Response to Planning Application

Application ref: WA/16/21/DOC

Description: Approval of details reserved by condition imposed under WA/75/20/PL relating to Conditions 9 Landscape Scheme and 11 Environmental & Ecological Management Plan.

Location: Star Plants Lake Lane Barnham PO22 0AL

PROPOSED
Landscape Plan
1120 - 010
February 2021
1500 @A3

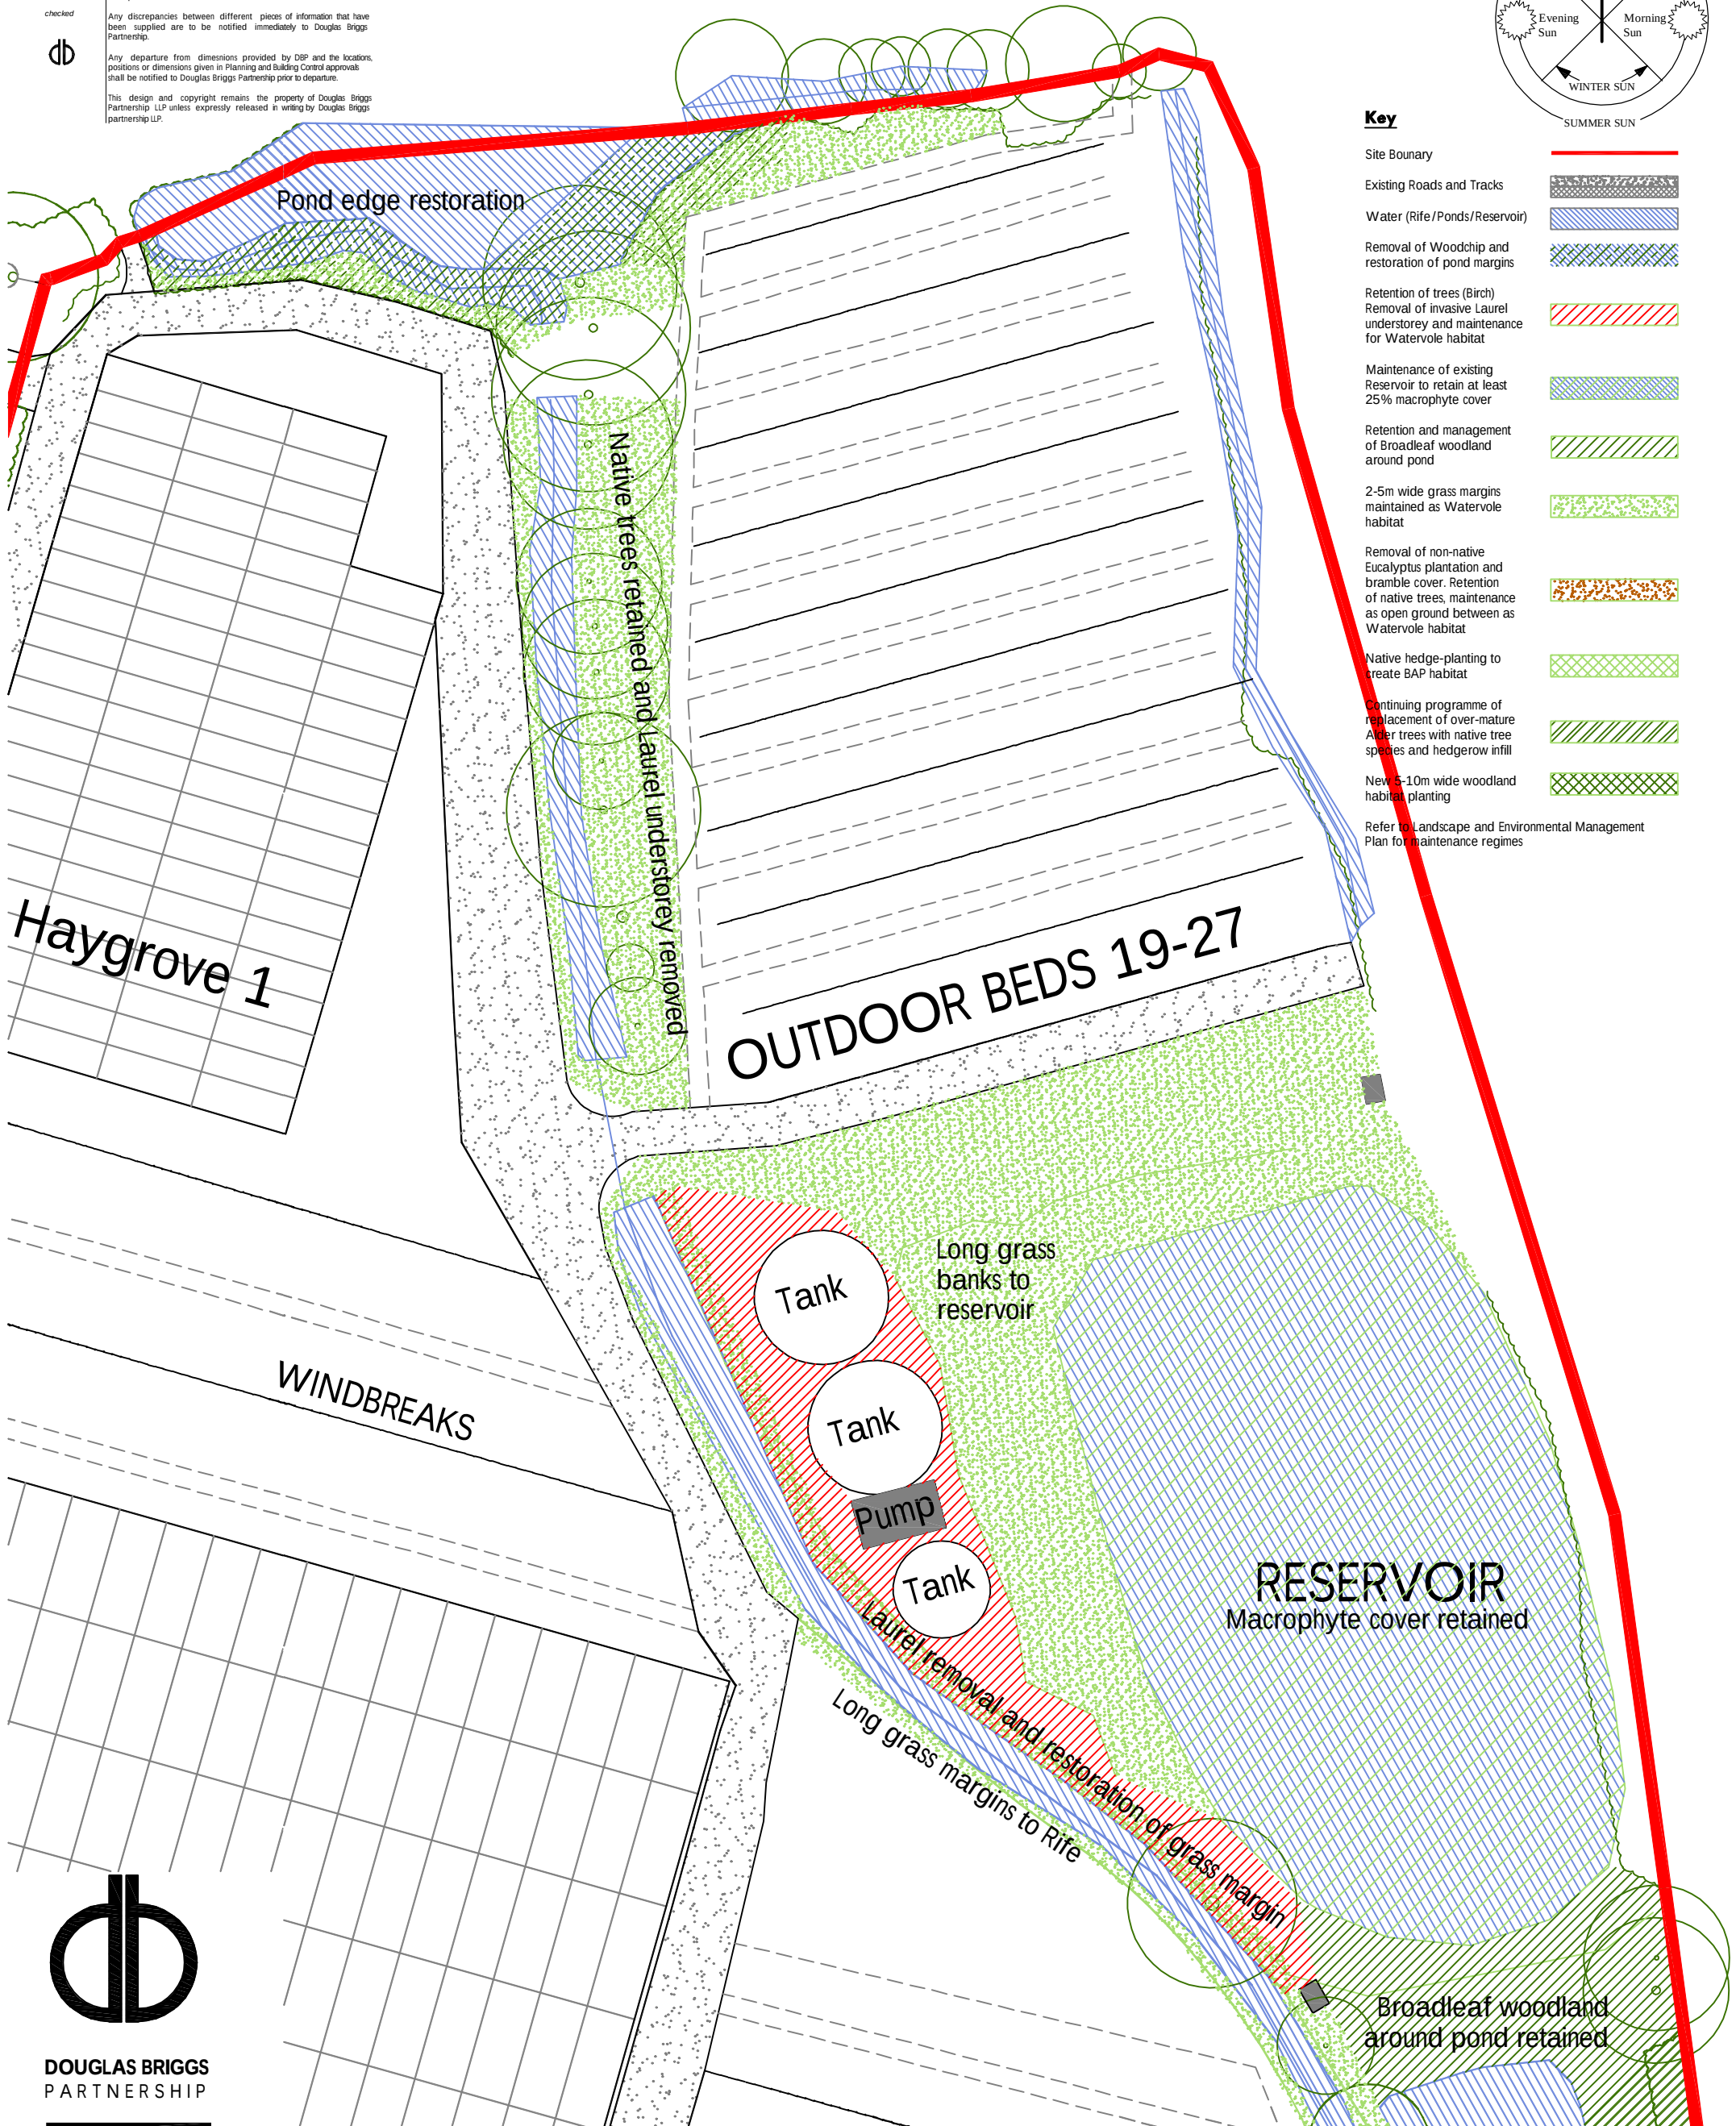
Further detail is requested to confirm the plant quantities for these areas and anticipated gapping up numbers. The detail is required to be shown on the submitted drawings and needs to show clearly quantities, species mix i.e. percentage of each within the species mix, planting densities (anticipated in gapping areas) and size of plants at time of planting.
